From: Liam Frayne <LFrayne@parracity.nsw.gov.au>
Sent: Wednesday, 15 April 2015 11:45 AM
To: Matthew Rosel
Subject: RE: MP09_0167 MOD4, 4-45 Macquarie Street, Parramatta - Notification of receipt of Response to Submissions

Council have reviewed the modified submission by the applicant, and the provided response to submissions. In general, Council would request that the Department consider our previous submission of 9 December 2014 as part of the further assessment of this application.

3101 South Elevation

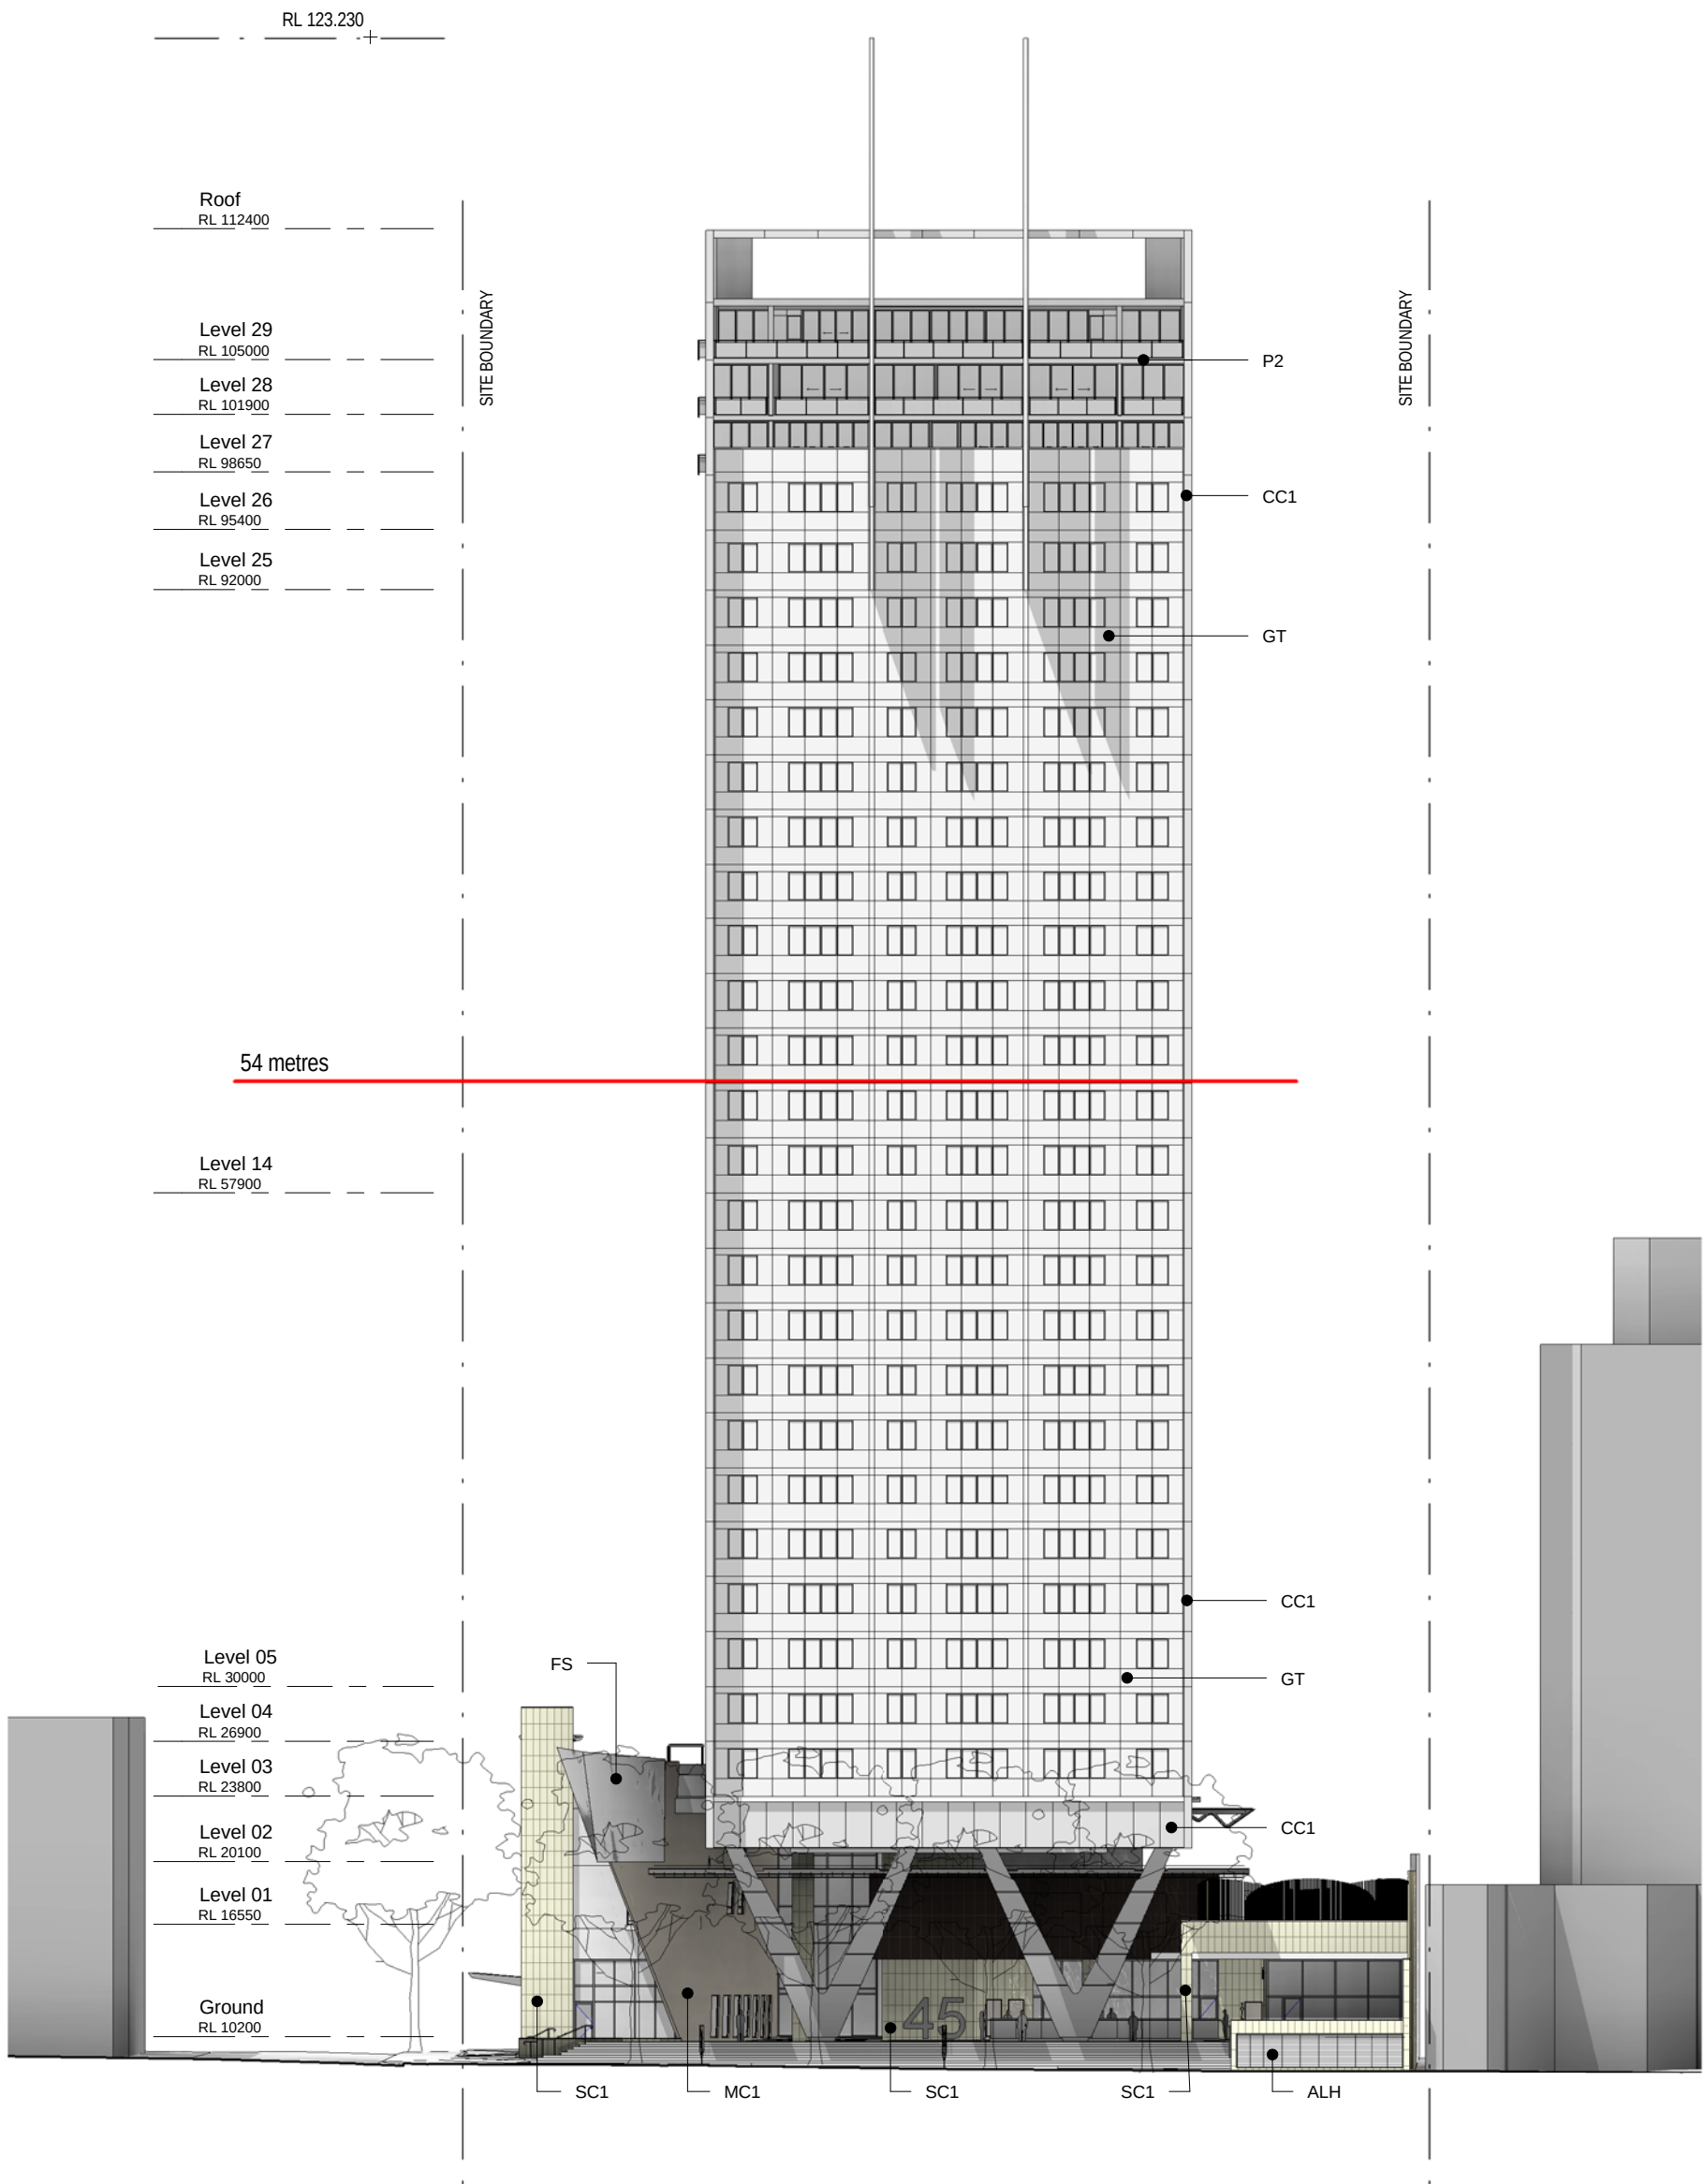
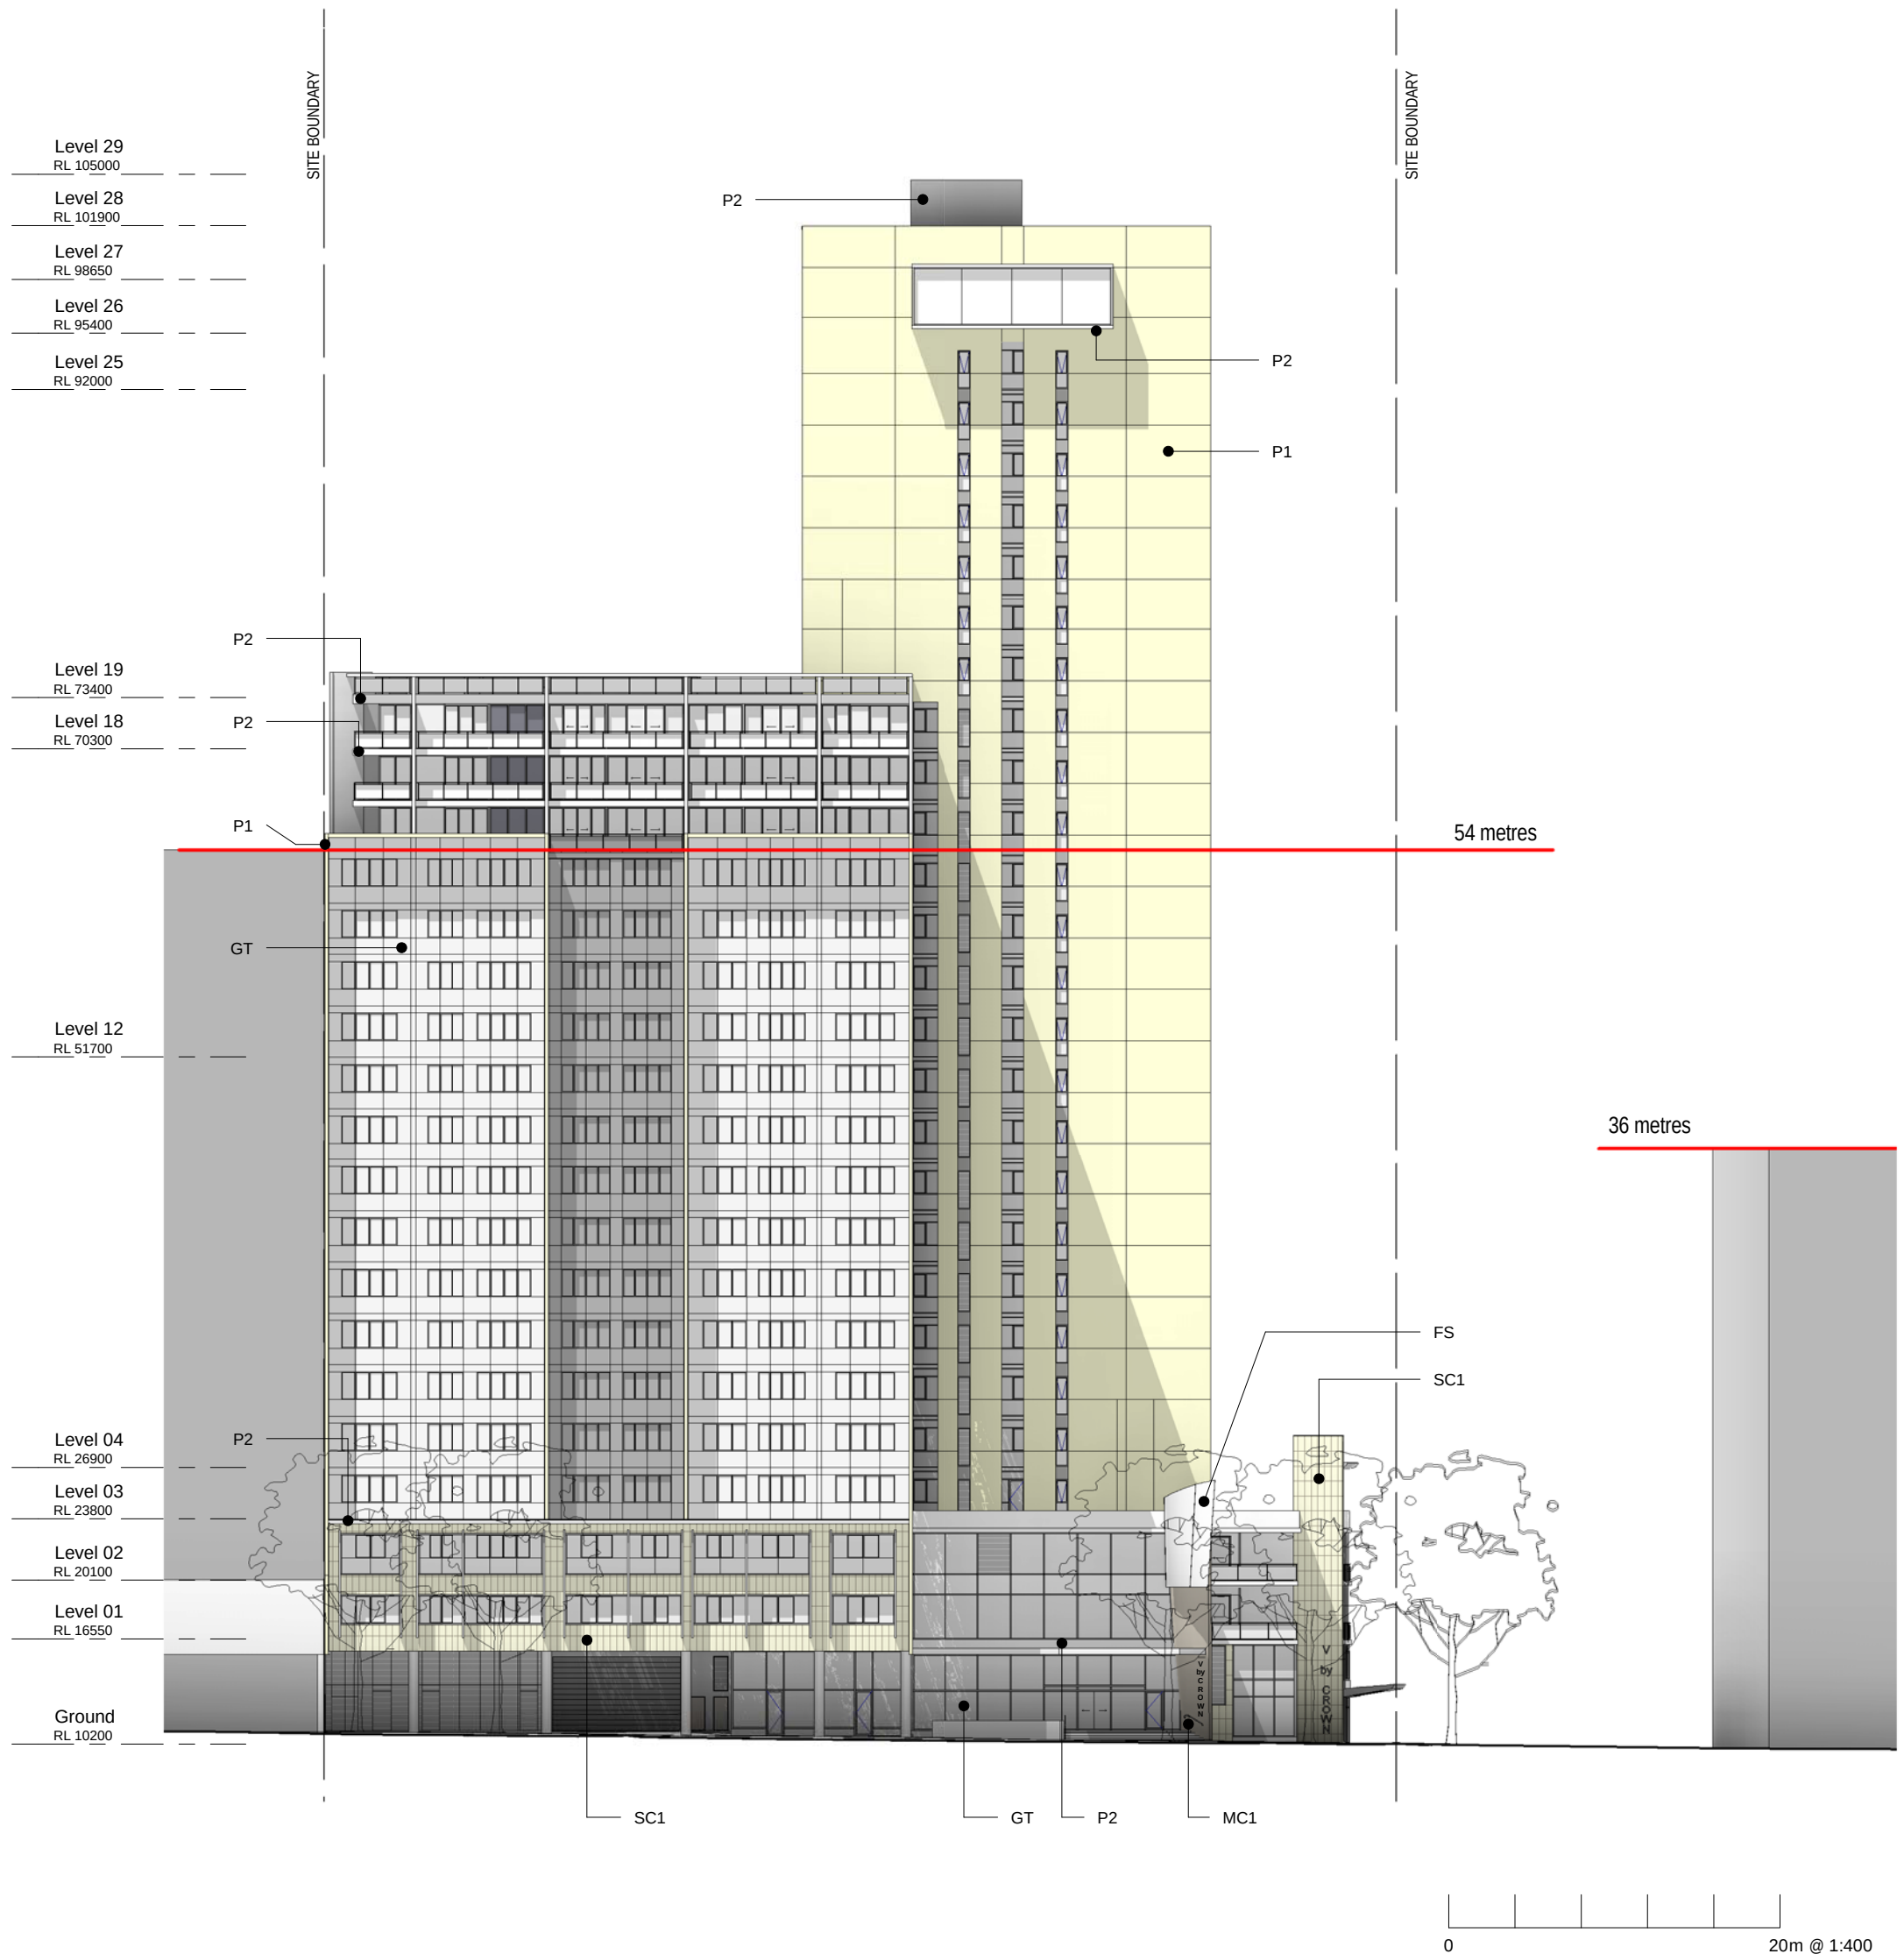
In terms of the southern elevation, we do not consider that the submission provides sufficient information to allow us to determine the adequacy of the response. In particular, a spot section of the portion of the lower south wing (which now includes the upper level setback) would enable an assessment of the effectiveness of the proposed design solution in resolving Council's concern about the lack of compositional clarity of that elevation.
